9 March 2009

**Re: Site 3, Australia Avenue, Sydney Olympic Park – MAJOR PROJECT No. 06_0127
Section 75W amendments**

Basement Level 1

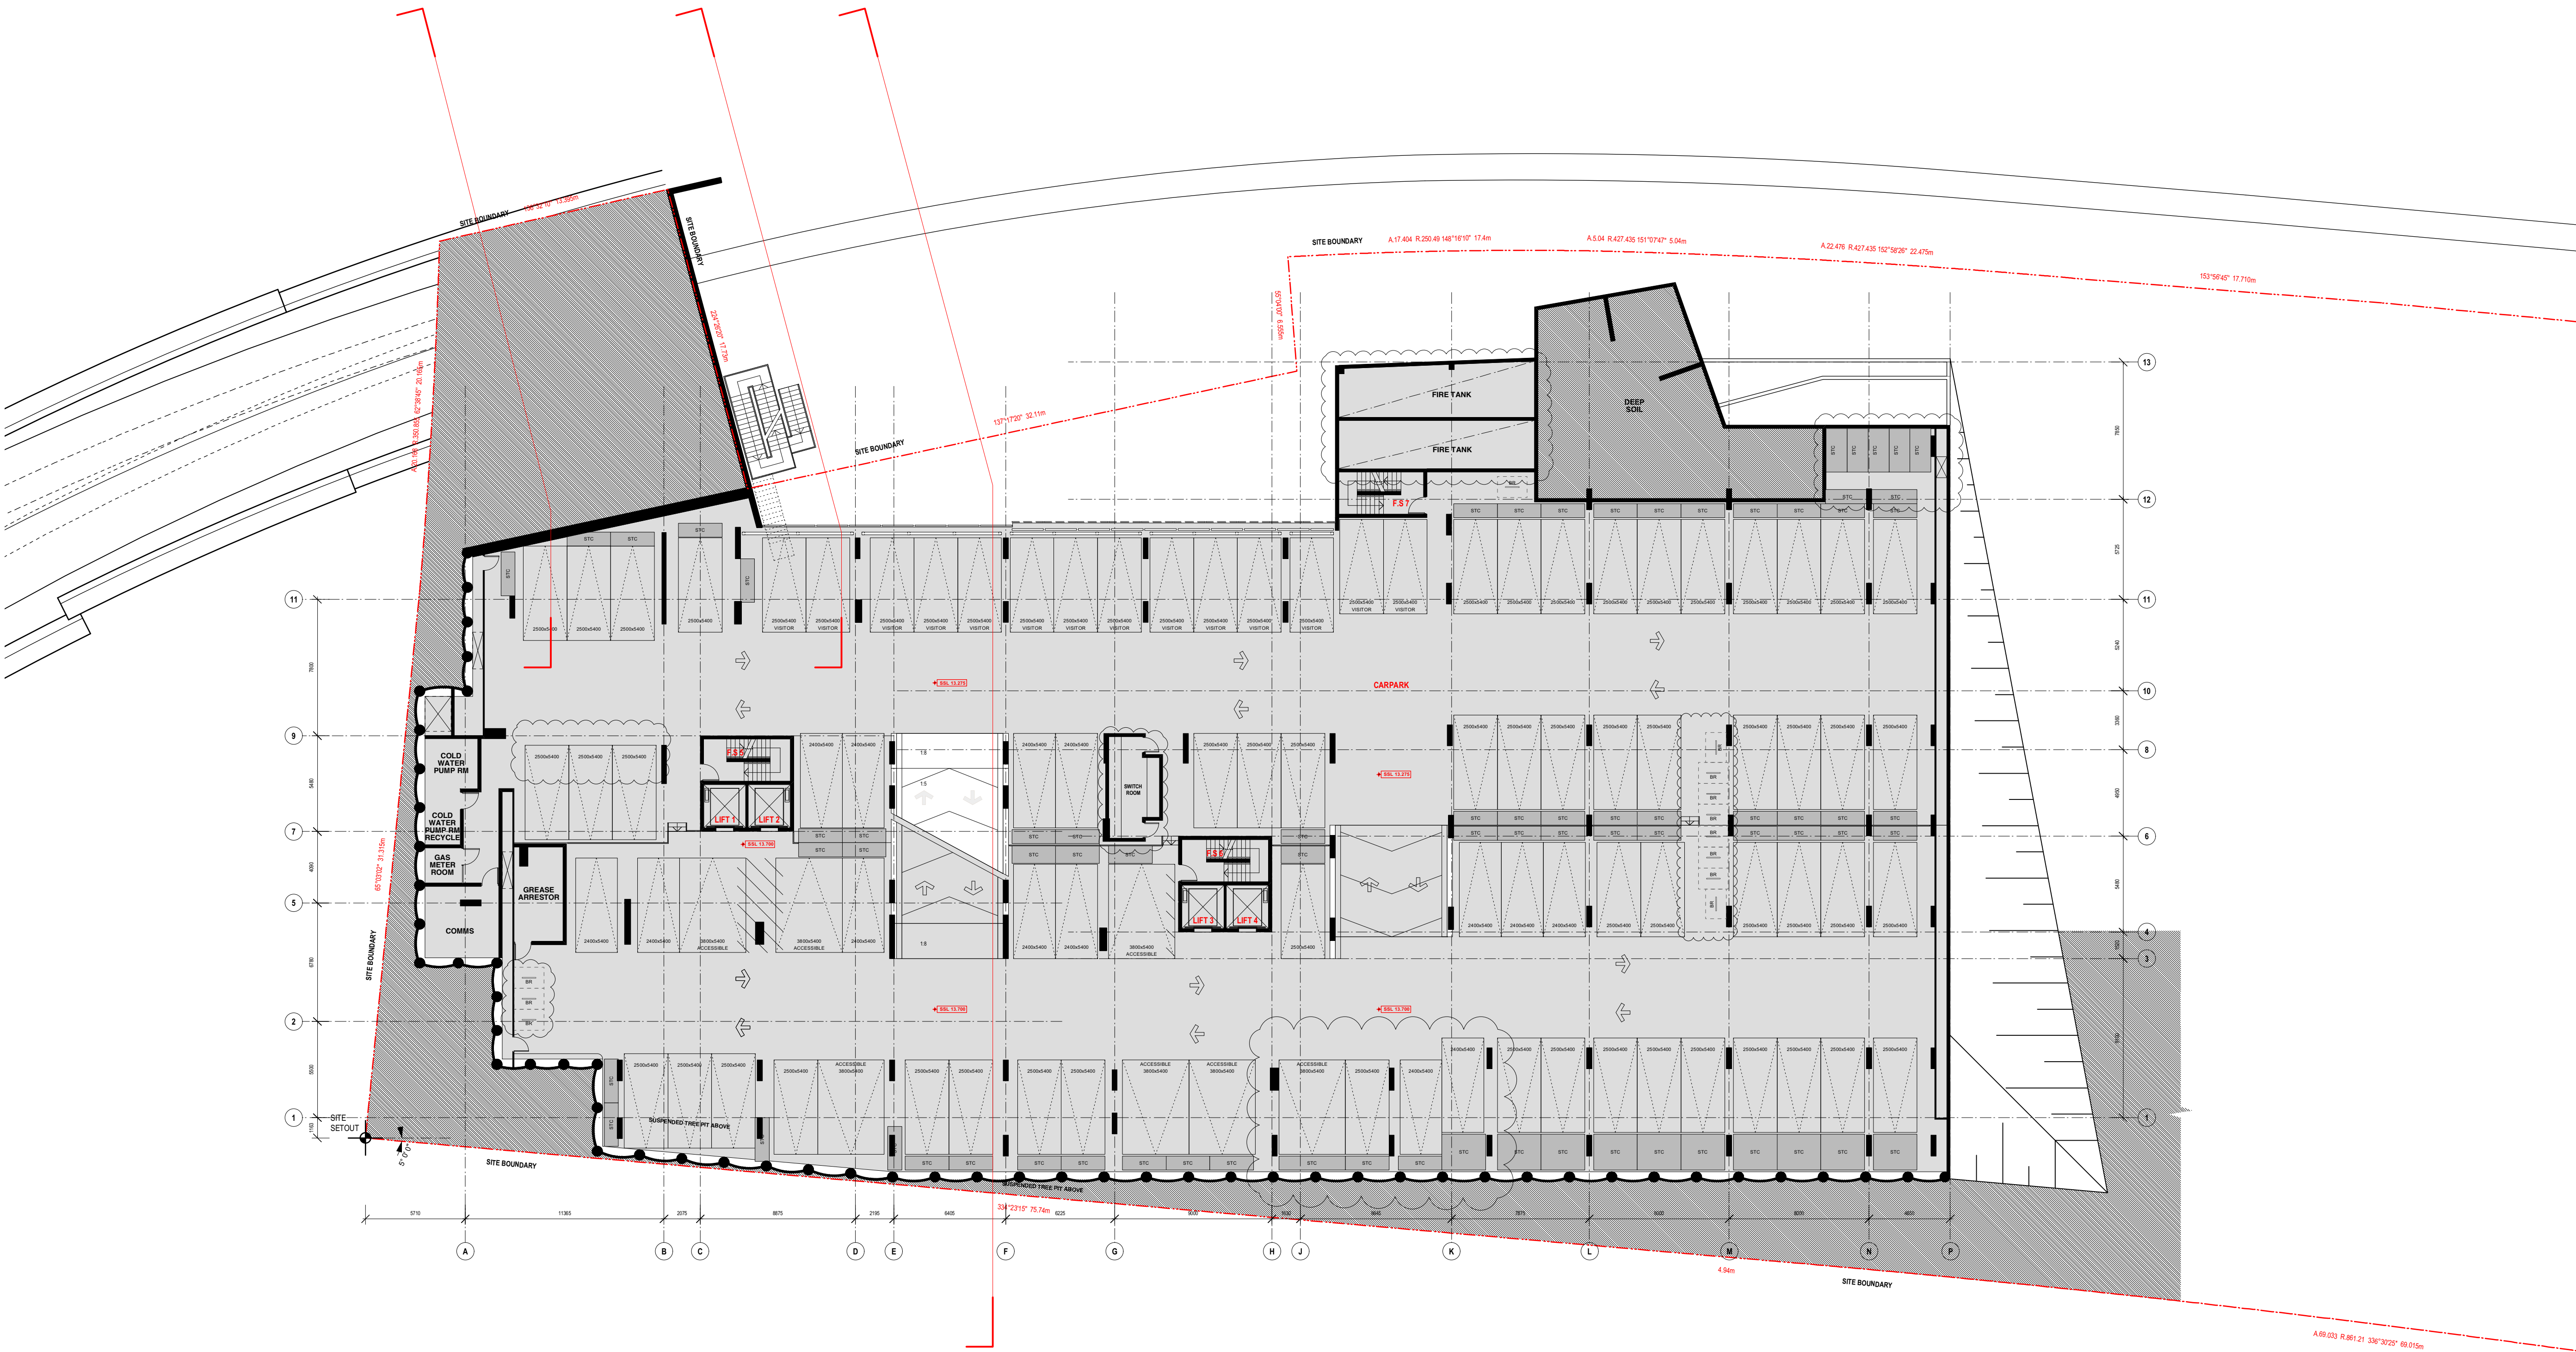
Within the 3 Basements the Plant, Waste and Service areas have been minimized after confirmation of services and equipments sizes. Through the reorganization of the car-parking spaces contained in the 3 Basements and at Ground, 3 additional car spaces have been provided increasing the total to 287 including 1 carwash bay. There are also now 9 x 2 tandem car spaces within this total which will be allocated to the largest units.

Ground Floor Plan

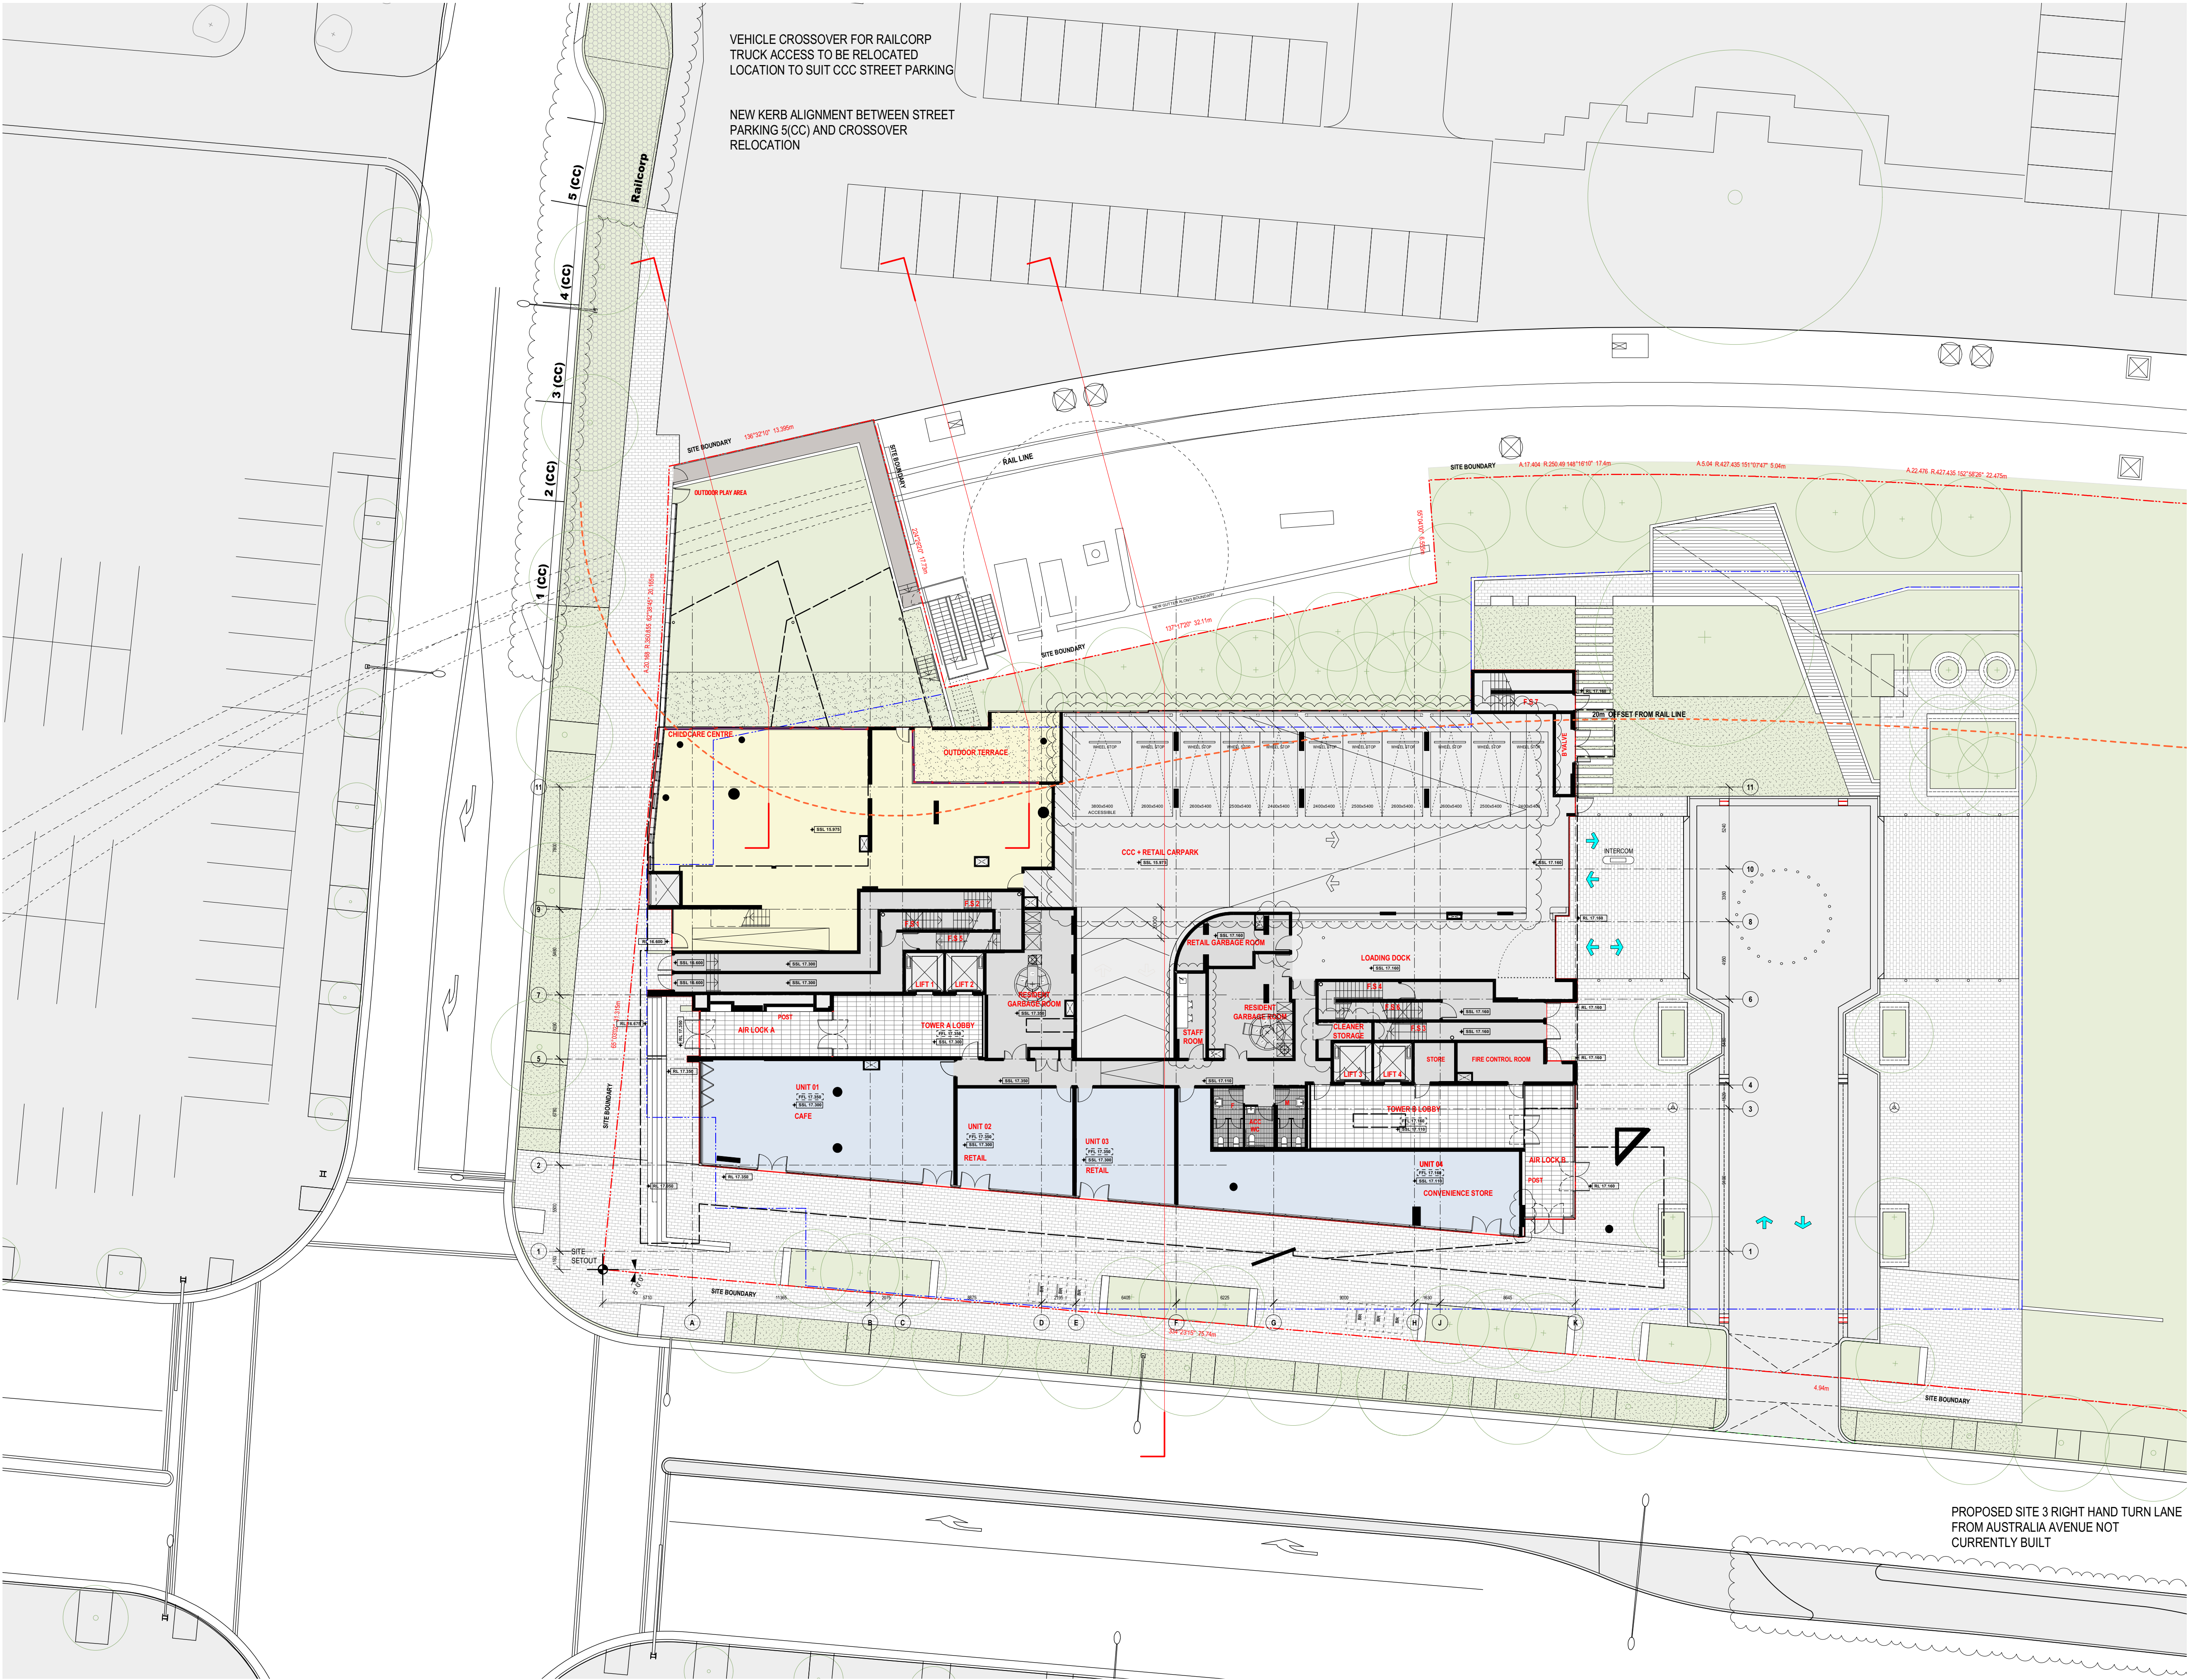
The Ground floor parking layout has been amended to provide pedestrian access to the Child Care Centre from the ground floor designated child care centre car parking spaces, separate from the vehicular thoroughfare as required by Condition B2 of the DA. Please refer to Ground Floor Plan DA006.

Level 01

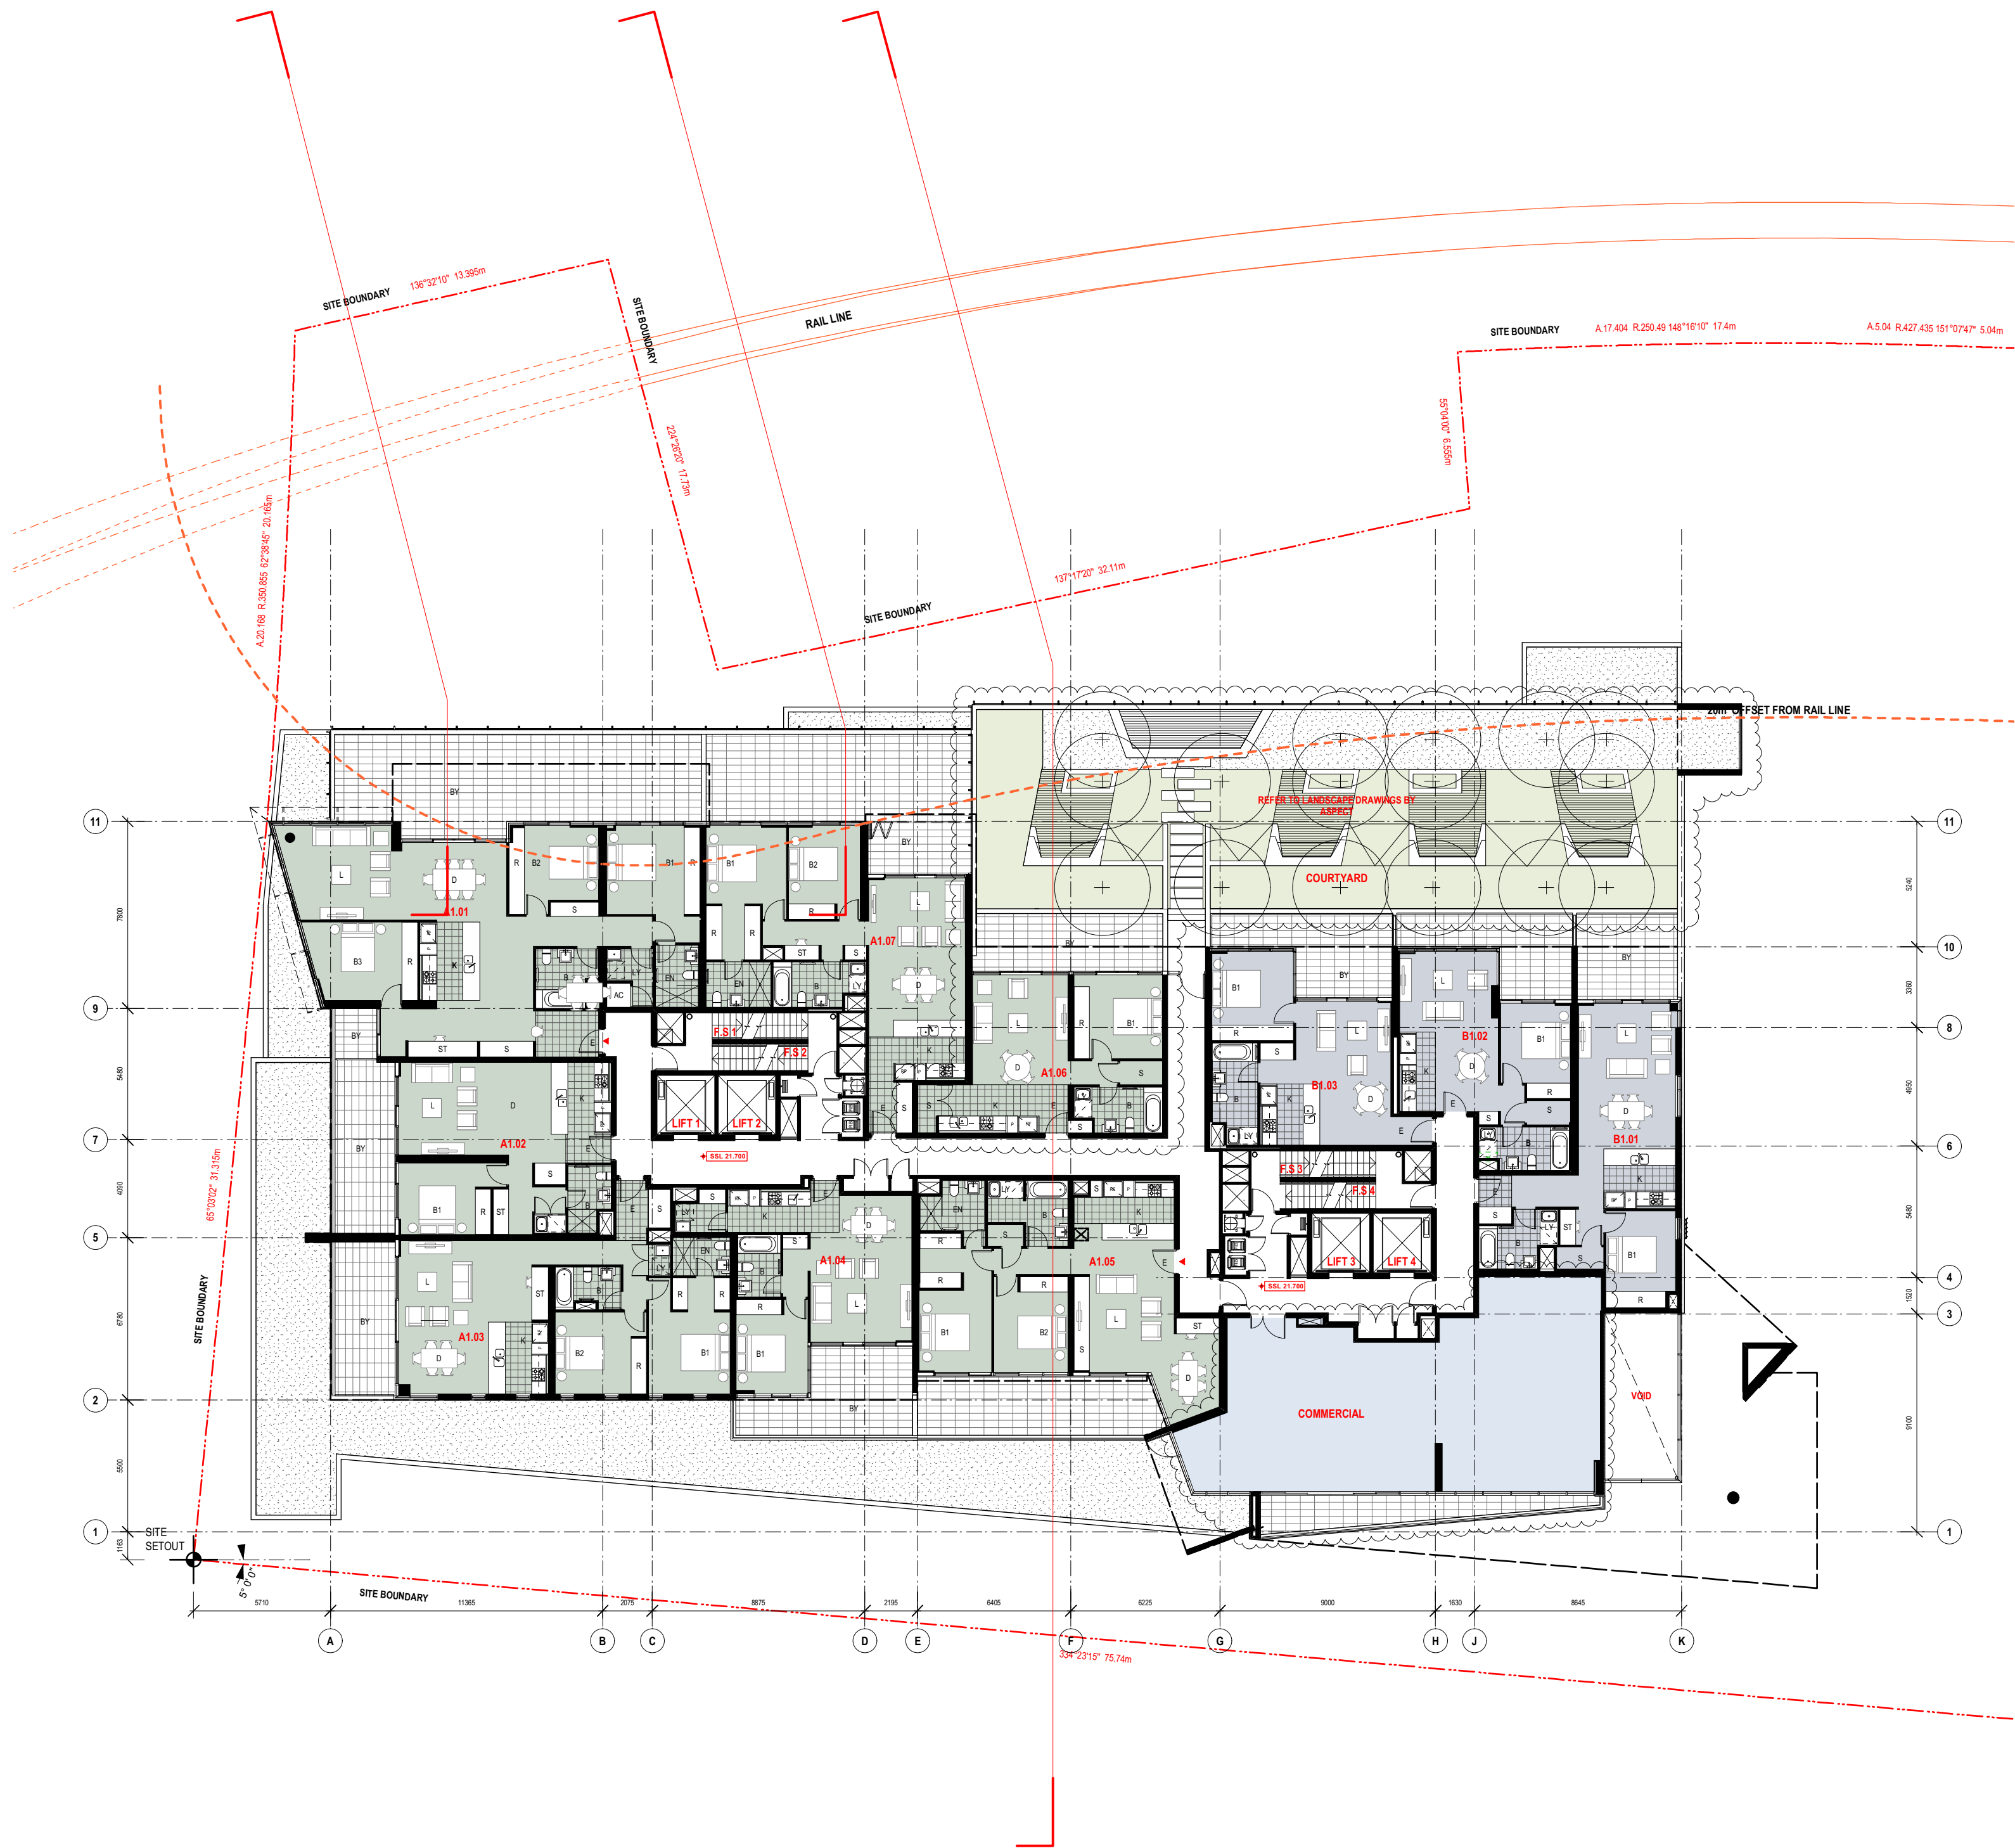
Therefore it is not regarded as detrimental that the small lap pool and associated plant room and changing facilities have been removed at the Level 1 Communal Courtyard. It will increase the acoustic and visual amenity of adjacent apartments in Tower B that face east over the courtyard as it's better suited to a landscaped outlook space with opportunities for quiet recreation than a noisier active recreation area. The landscaped solution provides softer landscaping and treats the planting as a series of garden beds rather than planter boxes. Nestled within the garden are a number of seating platforms that look east beyond the railway line. The increased planting provides a better visual buffer to the railway line and an improved visual foreground for the east apartments in Tower B.

The associated plant room and changing facilities have been replaced with a new 1 bed apartment. Access to the communal courtyard is still maintained at the same width beside the new unit.

Similarly the removal of the small gym at Level 1 is not regarded as detrimental given the opportunities for physical exercise and facilities in Sydney Olympic Park. The space has been converted into a small Commercial suite that may arguably provide more benefit to residents if it provides a new service in the area eg consultation rooms, solicitor, accountant.
